MAJOR DEVELOPMENT PLAN AMENDMENT

PART W 1/2 SEC 1, T 13 S, R 65 W, 6th PM FALCON, COLORADO

**NEW RV STORAGE FOR:
FALCON STORAGE
PART W 1/2 SEC 1, T 13 S, R 65 W, 6th PM
PEYTON, COLORADO**

REVISED PER EL PASO
COUNTY PLANNING
DEPARTMENT
COMMENTS
JULY 2, 2024

SDP1.2

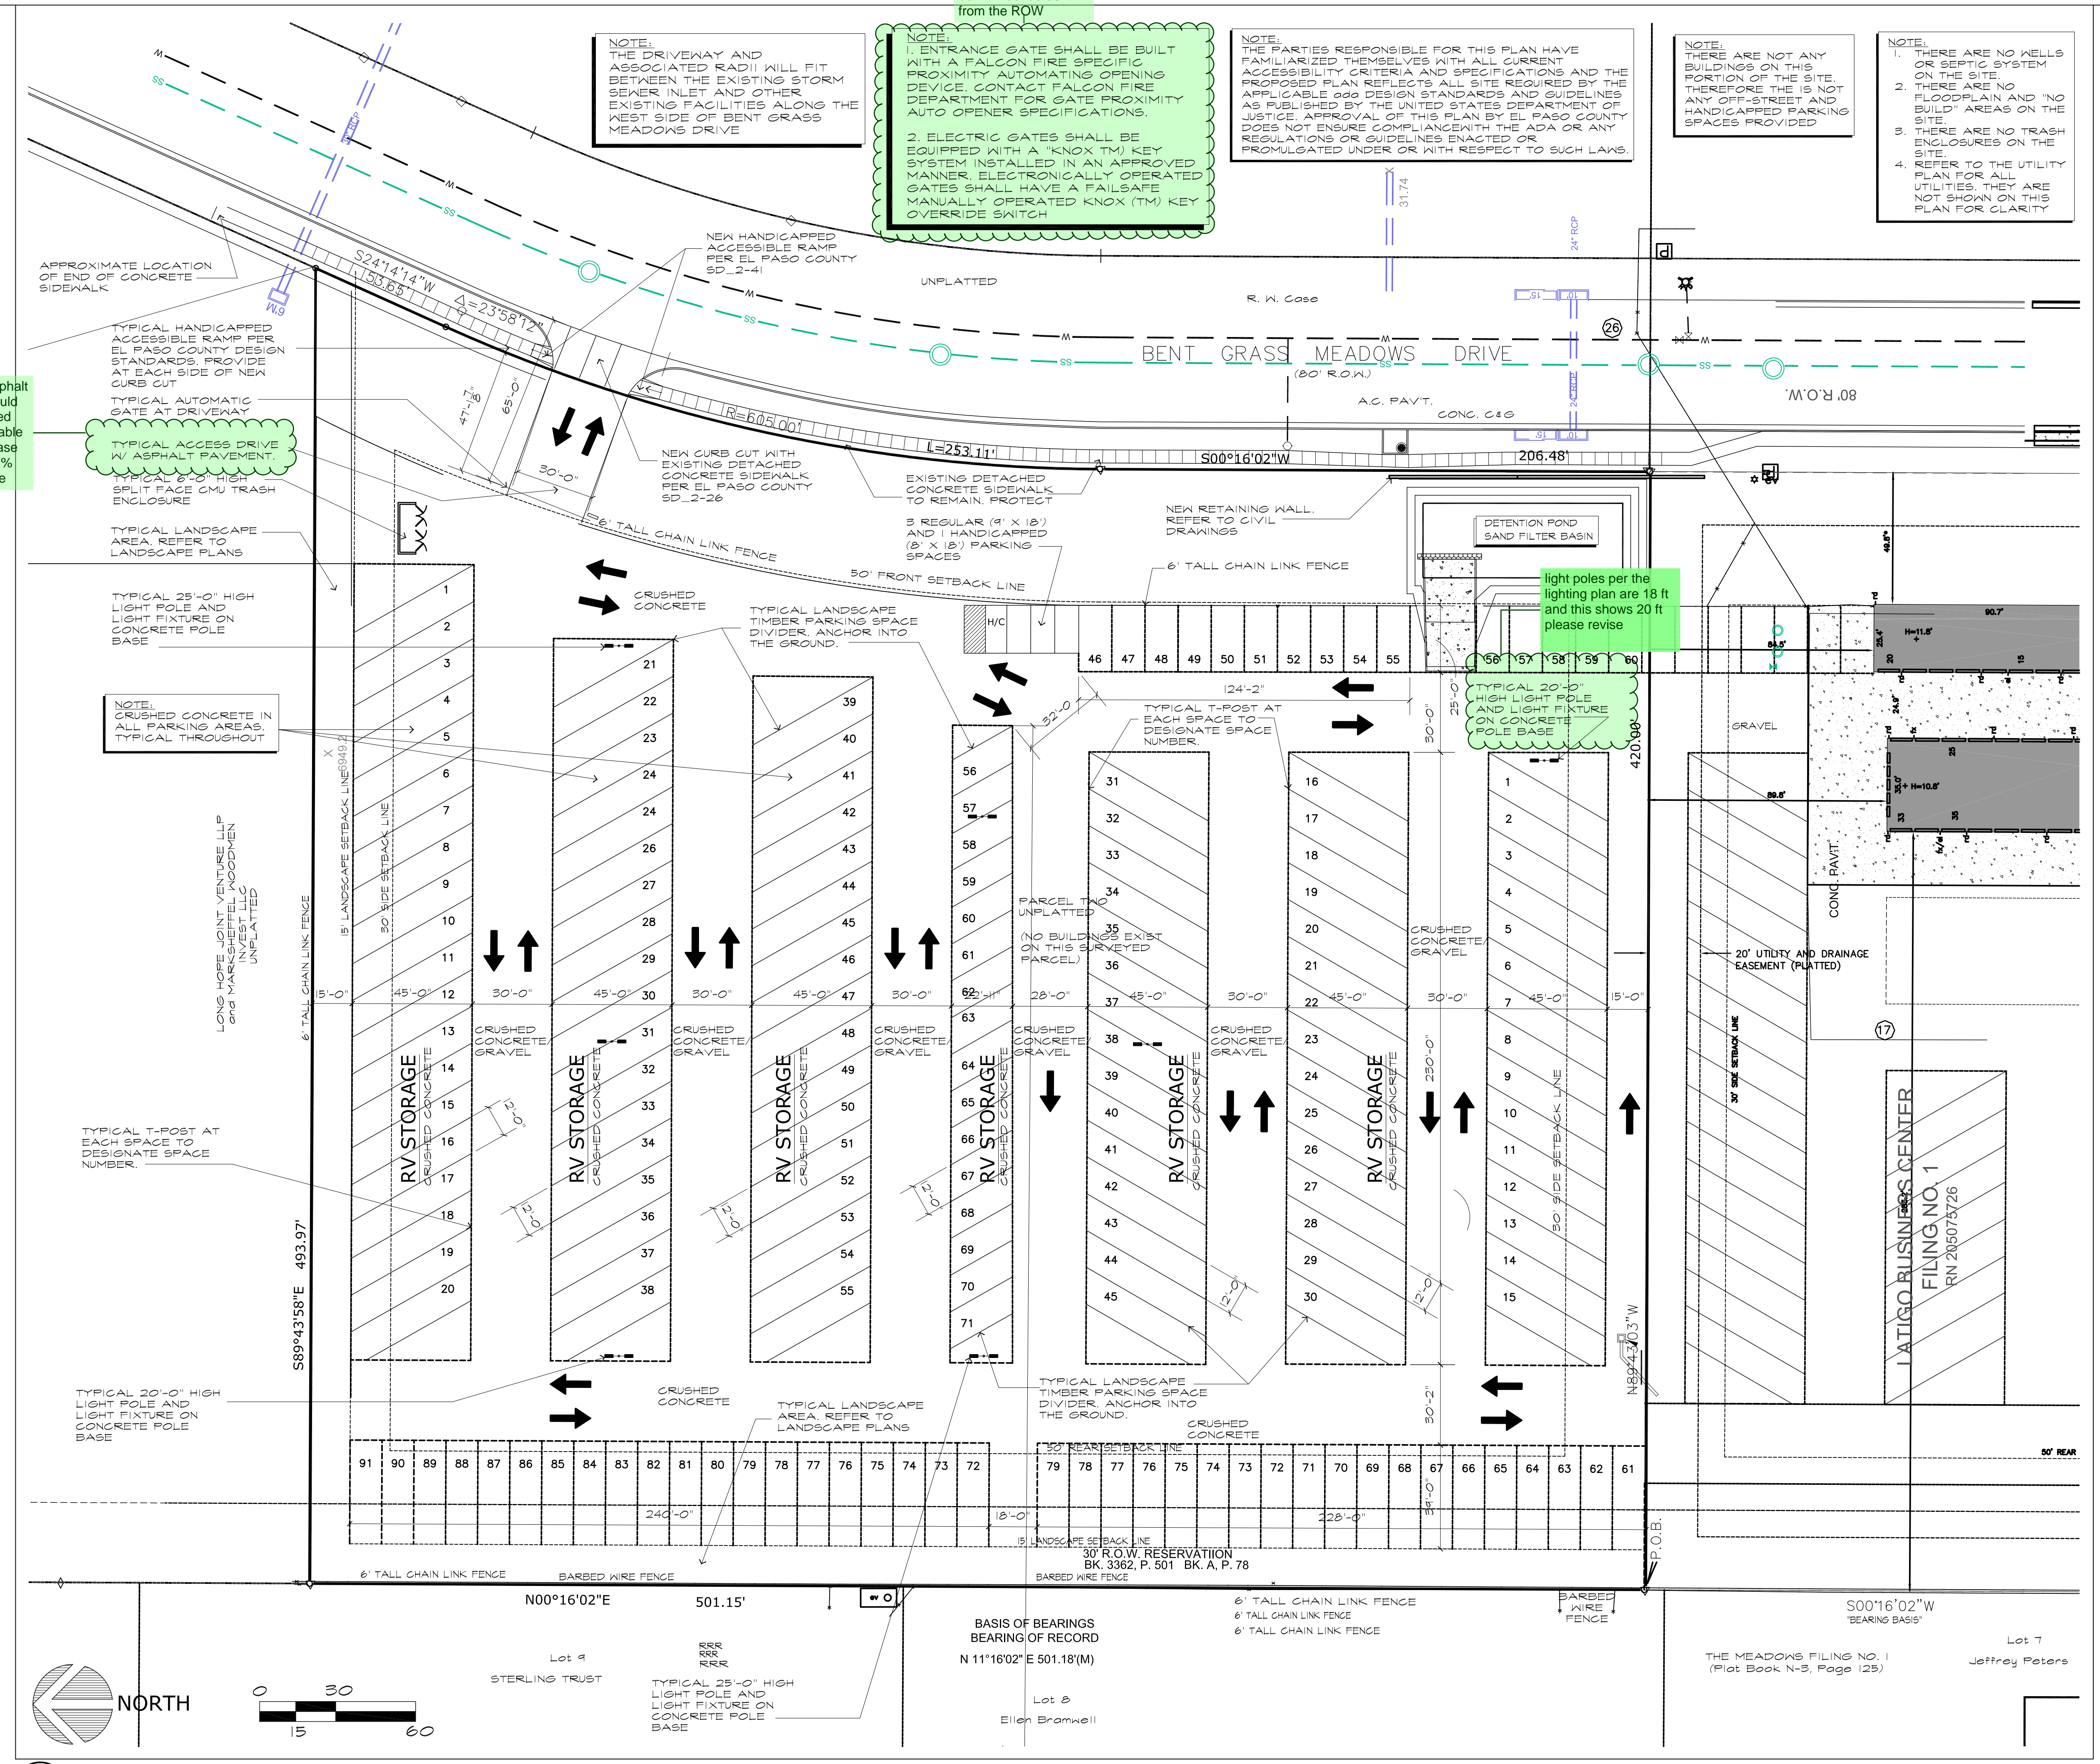
Please also identify the amount of storage spaces, i.e. 92 per the TIS and site development plan

revise as note on the site plan indicates an asphalt driveway

UNRESOLVED V1 & V2 COMMENTS:
Please provide:
-total gross building square footage
-landscaping percentage
